Submission for Job: #6010 SSD 6010 - One Residential Building (Student Accommodation) within Darling Drive Plot

SSD 6010 - One Residential Building (Student Accommodation) within Darling Drive Plot

Submission by:

23 July 2013

21st June, 2pm

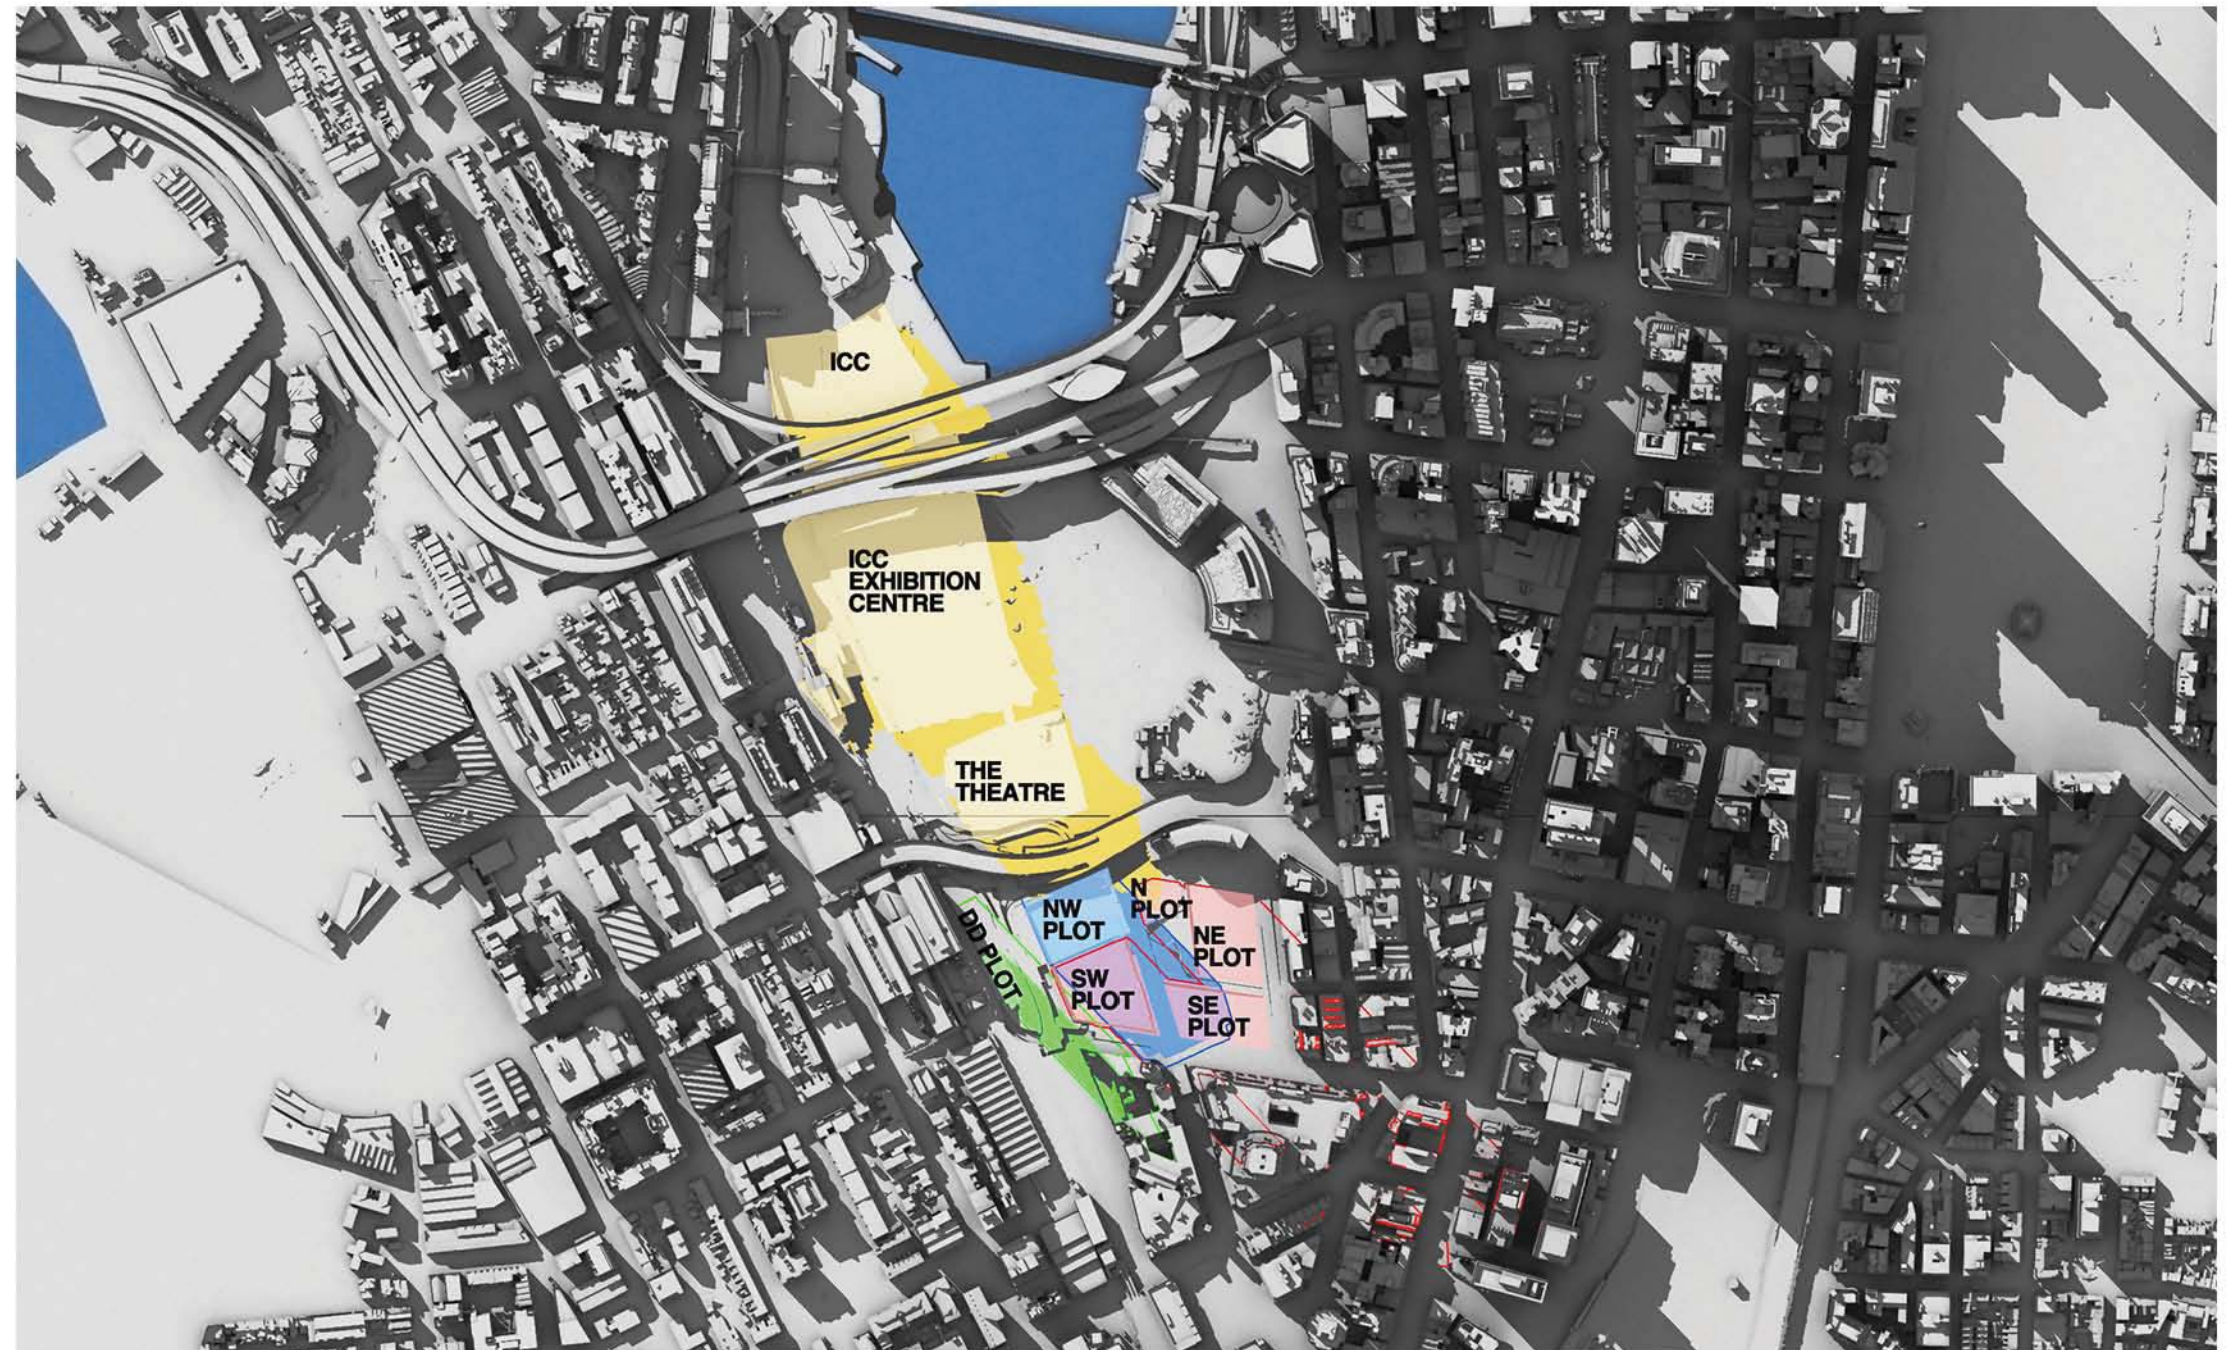
At 1pm the existing shadowing has been substantially, although not entirely, removed. However, overshadowing of lower levels of the west façade by the concept proposal parameter plan shadows for the N,NE and SE plots has already started.

By 2pm the existing shadowing has been totally removed. However, overshadowing of the west façade by the SSDA4 and SSDA5 buildings has appeared and risen further up the west façade than the concept proposal parameter plan shadows for the N,NE and SE plots, which is still present.

At 3pm, the proponent states correctly that 45-45% of the western façade is overshadowed by the SSDA4 and SSDA5 buildings.

It can be concluded that, as a result of combination of the proposed development with existing shadowing of the west façade, some single aspect apartments on the west façade and the south-west dual aspect corner apartments which currently receive less than 2 hours direct sunlight to habitable rooms and 50% of the private open space between 9am and 3pm on 21 June will suffer additional overshadowing. It is beyond our skills to count the number of such apartments. We note that the proponent has made no attempt to do so.
